**Baiada Intergrated Poultry Processing Facility (SSD 9394)
Response to Submissions**

Attachment A – The Department of Planning, Industry and Environment Issues

Table 1: Proposed Chemical Storage Volumes and Locations

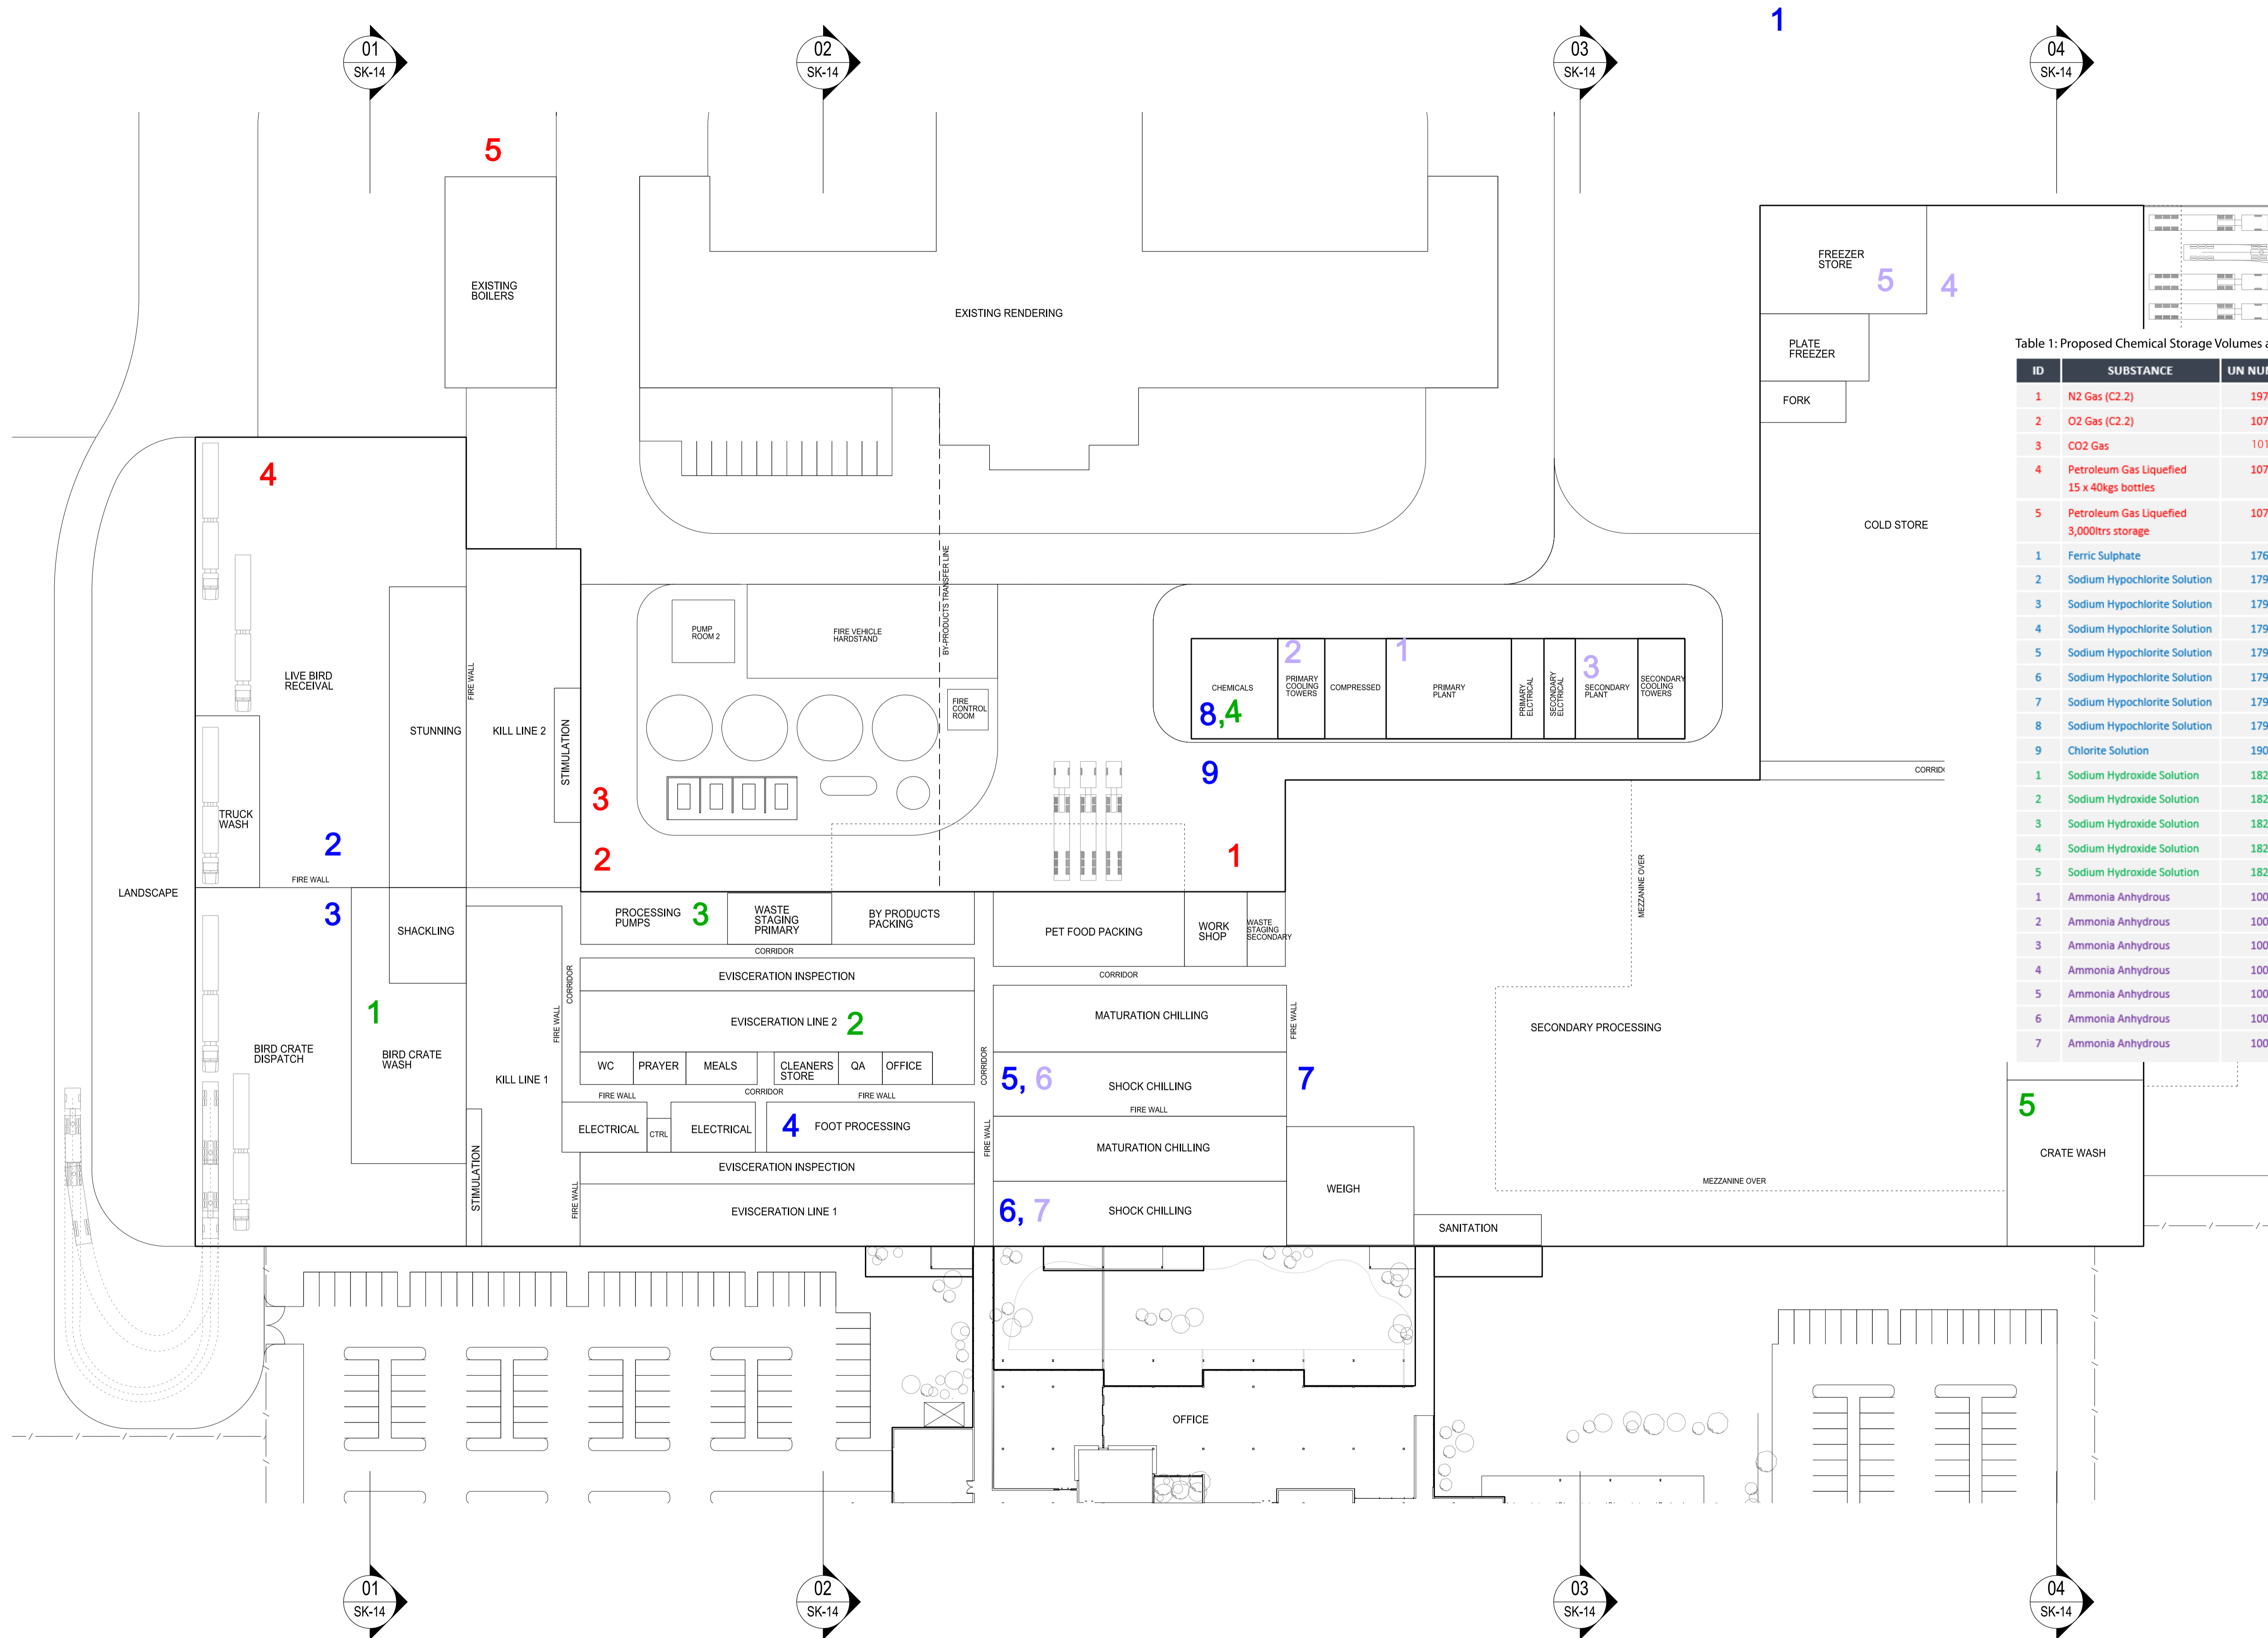
8. Please confirm the actual gas medium used on site for the rendering plant boiler house and other:
 - a. is it natural gas supplied via a pipeline from the gas network?

- b. is it Liquefied Natural Gas (LNG) (as referred to throughout the EIS and as shown on drawing number SK01 Rev 2, dated 20 June 2019) or
 - c. is it Liquefied Petroleum Gas (LPG)? And where are the LPG tanks located?

9. Section 4.15 of the EIS refers to LNG, however Table 3.3 of the EIS refers to LPG. Please confirm and show on a site plan the: location, distances from buildings, size and quantity of bulk storage tanks for the dangerous goods Class 2.1 that is currently on site.

10. Table 33 of the EIS: 'Indicative Chemical Storage Volumes based on Hanwood Processing Plant' should include and list dangerous goods that will be relevant for the Oakburn Processing Plant.

12. Please confirm the quantities listed in Table 33 of the EIS for Ammonia Anhydrous, Class 2.3 in particular those pertaining to the enclosed refrigeration systems. The EIS states 1,200L each with a conversion to 0.0009T which may be an error and may need to be corrected. To assess the aggregate storage of anhydrous ammonia for the processing facility, please provide further detail regarding the enclosed refrigeration systems, and whether they are separate systems or part of one unit.
